PRE-HEARING STAFF ANALYSIS

Rezoning Petition No. 2008-52

Property Owner: Novant Health, Inc.

Location: Approximately 81.8 acres in the northeast quadrant of the intersection of I-485 and Albemarle Road

**Site Plan**

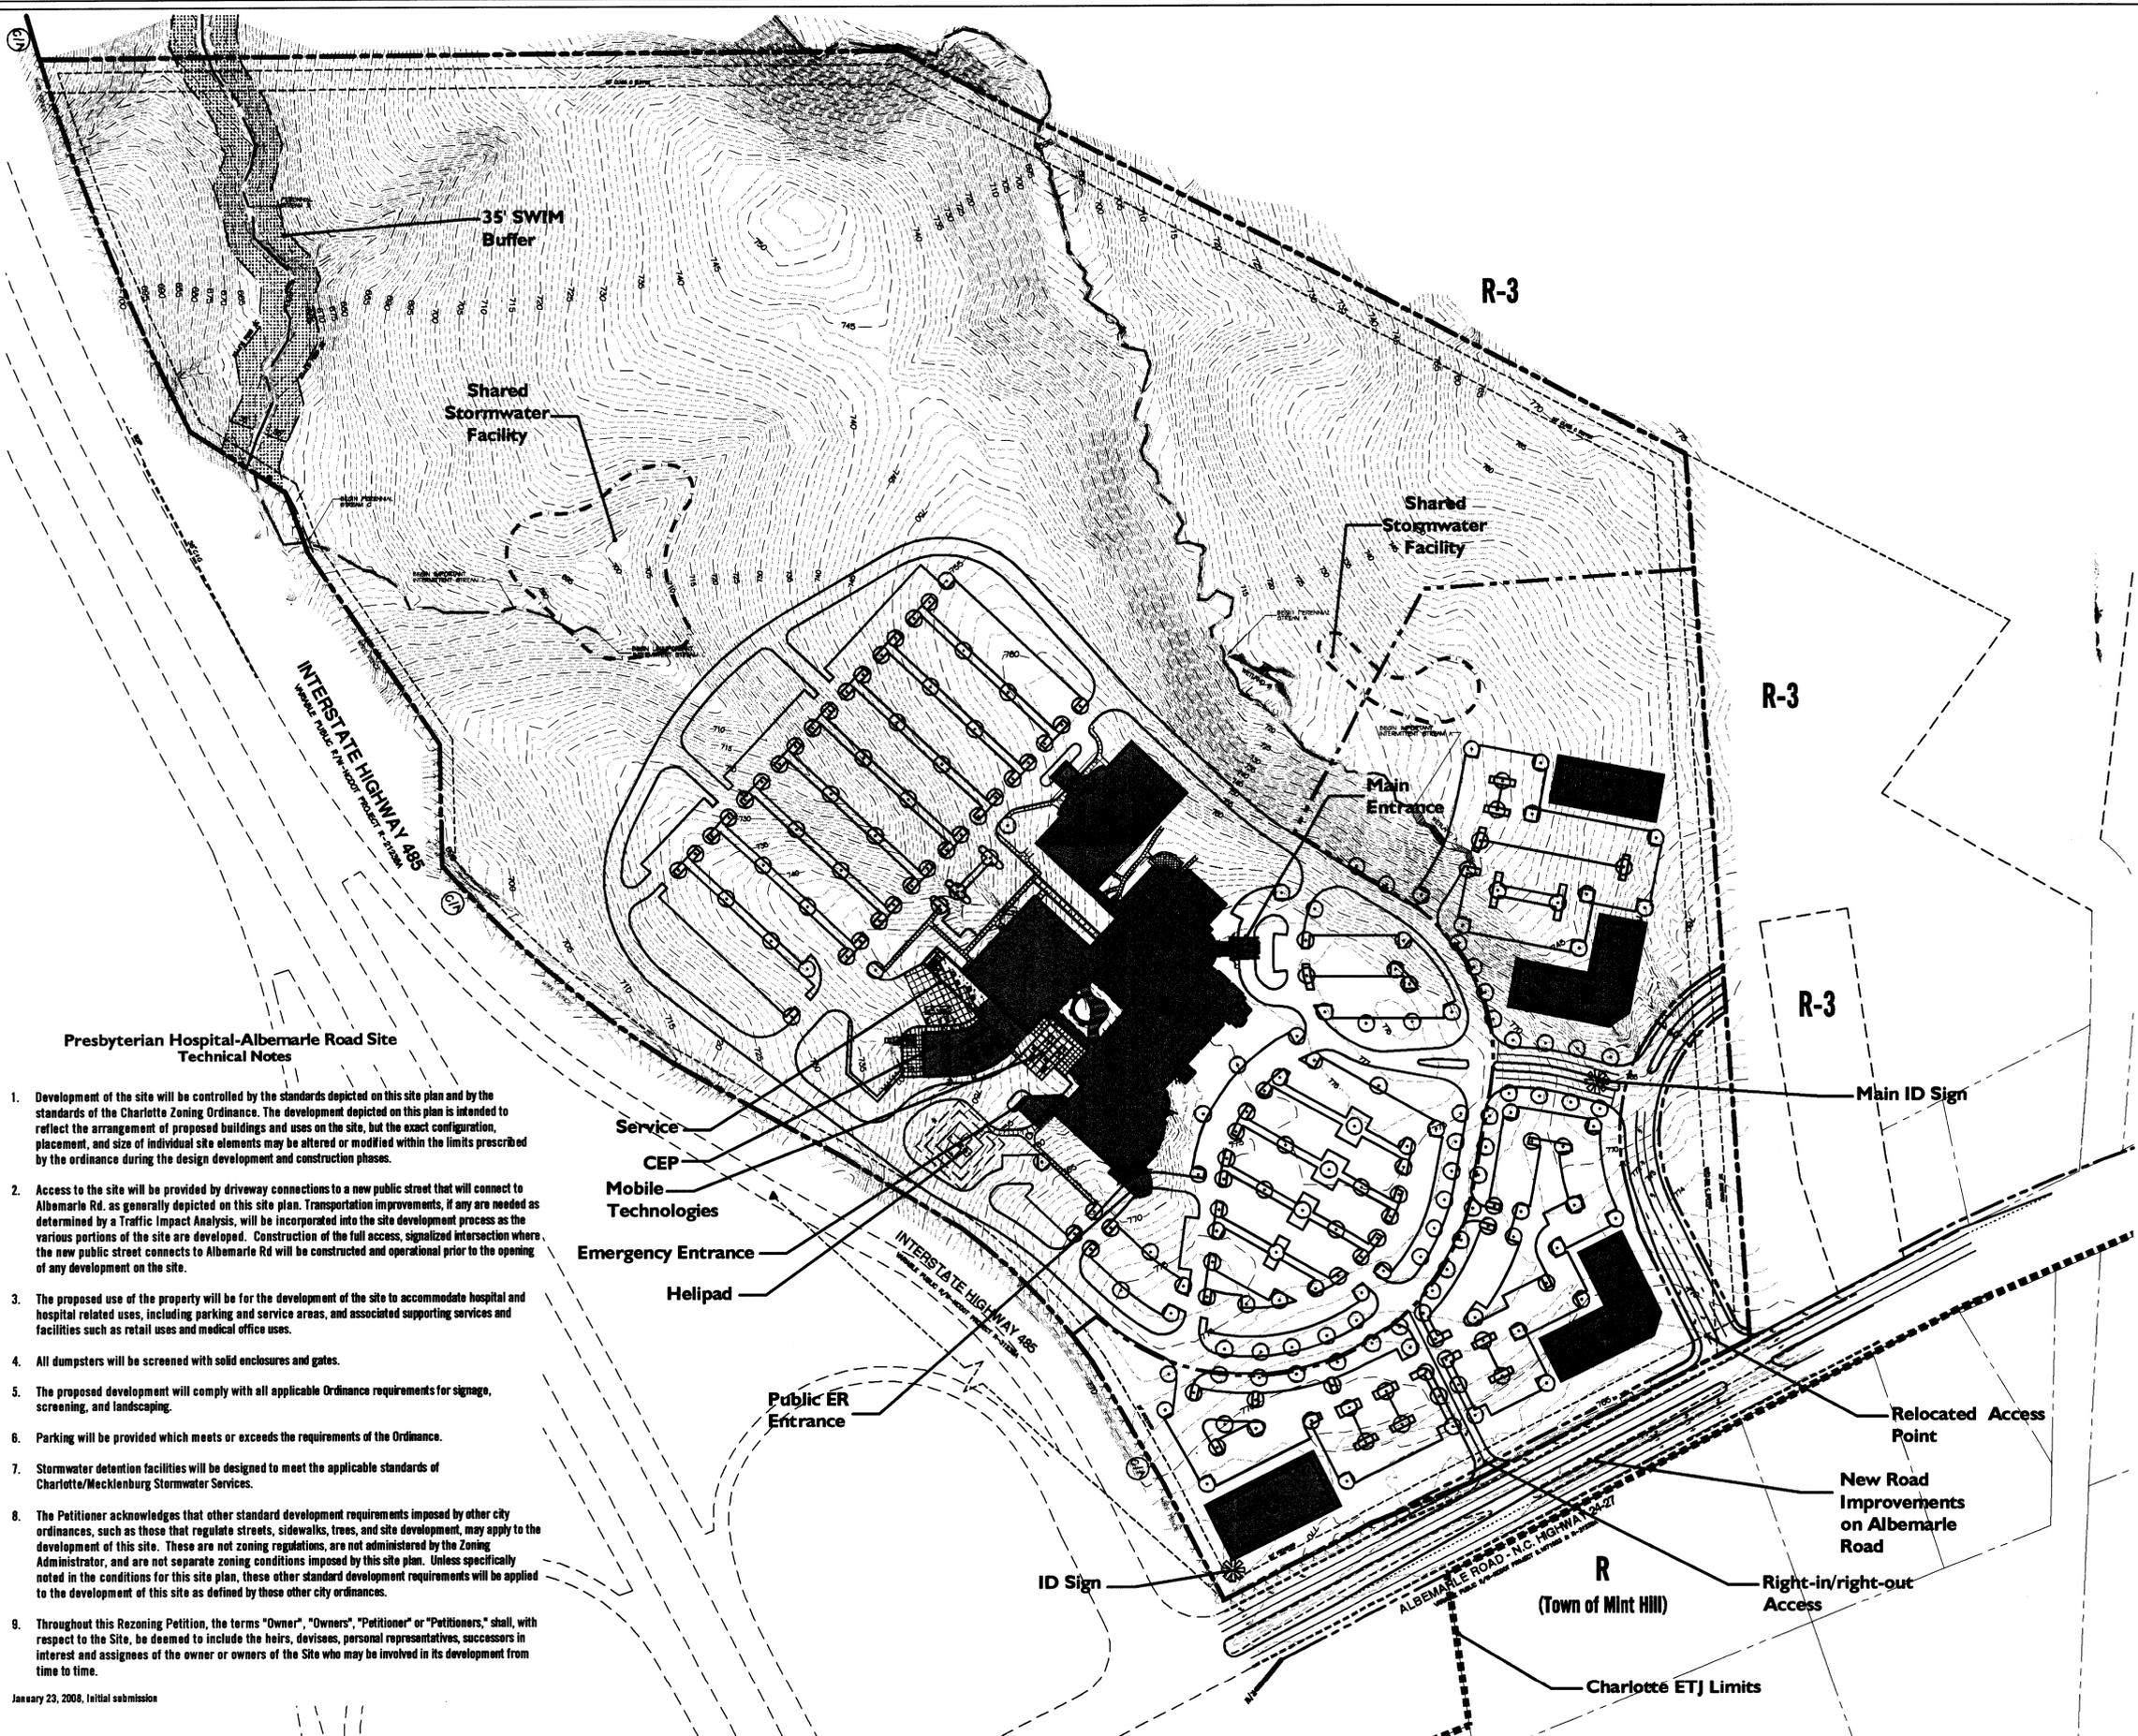
Albemarle Road (NC 24/27) is designated as a Strategic Highway Corridor by NCDOT, requiring controlled/limited access. Since there are few alternative east-west roads, it is critical to maintain the capacity of this highway. The access currently shown on the site plan is inadequate and significant additional road improvements will be needed to make this proposal function and maintain capacity. See attached memo for detailed comments. When the review of the TIS is completed additional comments will likely be forthcoming.

Connectivity. A new public street will be needed through the site and connecting to the residential area north of the petitioned site. That connection is not currently shown on the site plan.

- The proposed 20-foot landscaped sideyard along I-485 is inadequate to screen a 110-foot high hospital. The landscaping needs to be increased to 50 feet in width and planted to a Class “C” buffer standard.

- A public street needs to be extended from Albemarle Road to the northern boundary of the site in the eastern half of the site.
- There is a large tree save area designated to the rear of the hospital, outside the “phase one limits”. This designation conflicts with Note #3, which indicates that this may be an area of future development. There are no commitments to tree save within the phase one limits and this needs to be addressed.

**Technical Data Sheet**

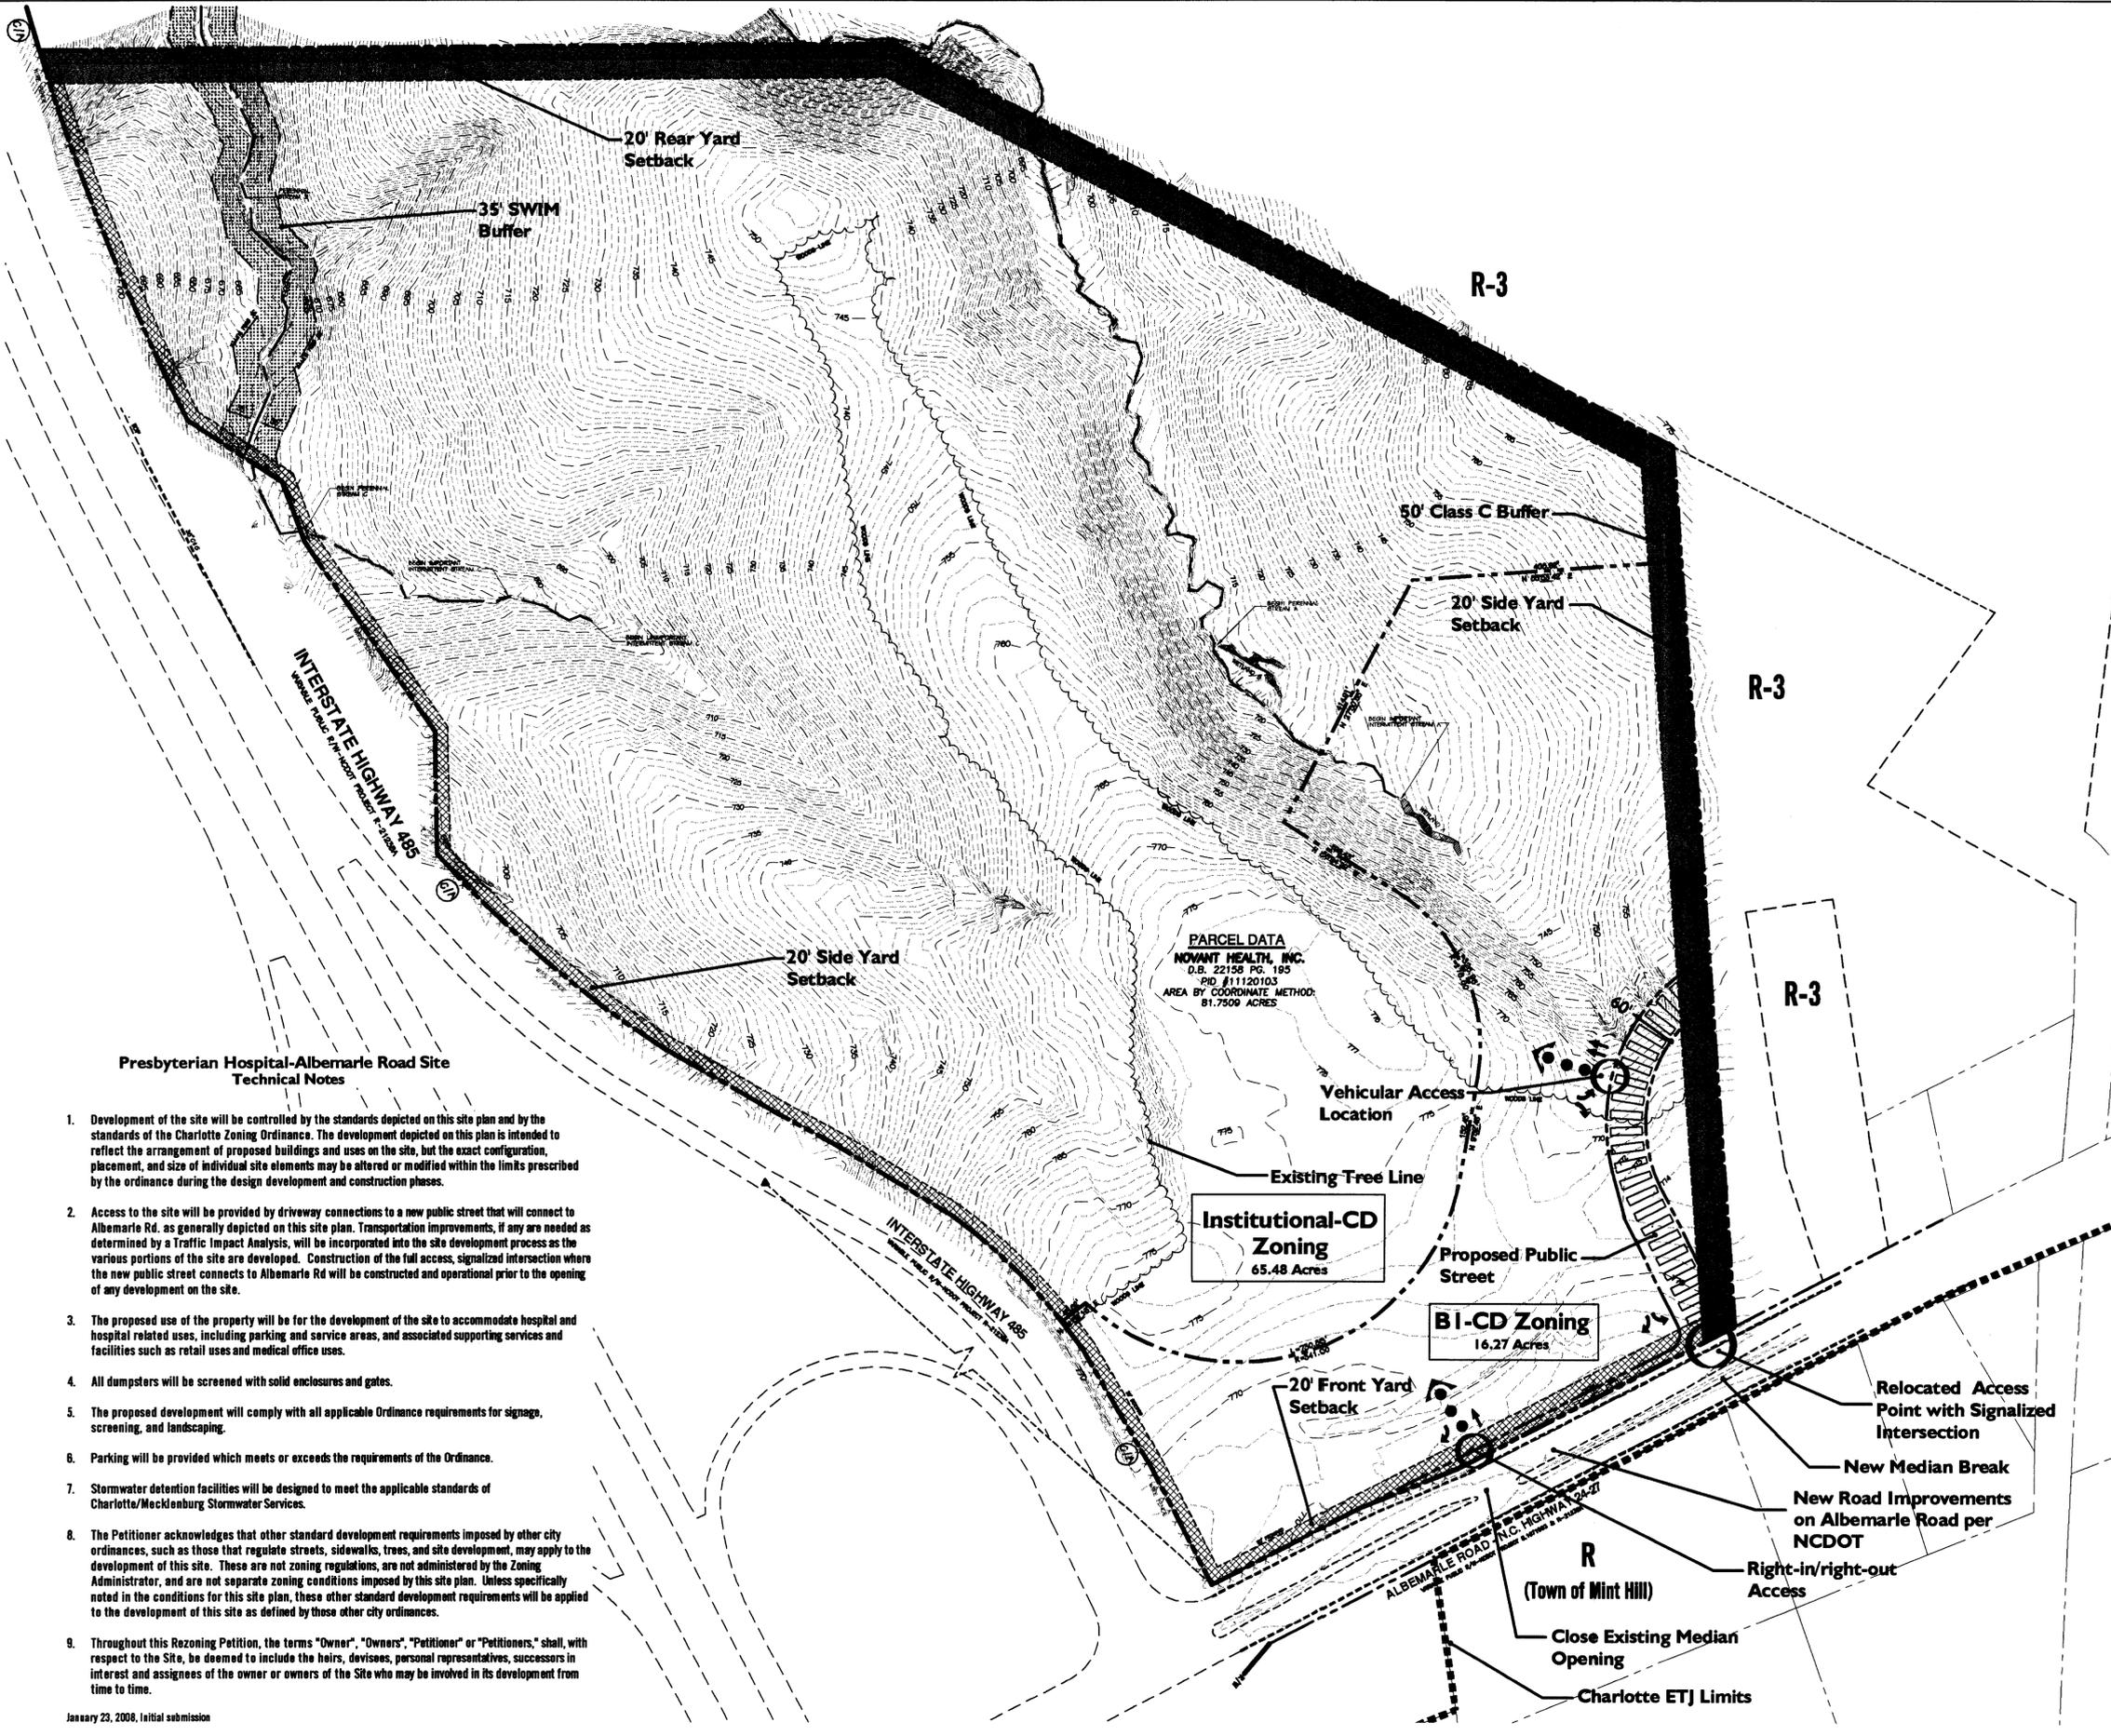
- Add a note that if meters, junction boxes, or similar utilities are placed on public street frontages of buildings they will be adequately screened.
- The stormwater note needs to be modified to make it clear that the petitioner is agreeing to meet the standards of the Post Construction Ordinance even though that ordinance is not effective until July 1, 2008.

- While the site plan contains an annotation regarding right-of-way dedication, a note needs to be added that specifically agrees to “dedicate and convey” the right-of-way identified in the Traffic Impact Study as being needed along Albemarle Road.
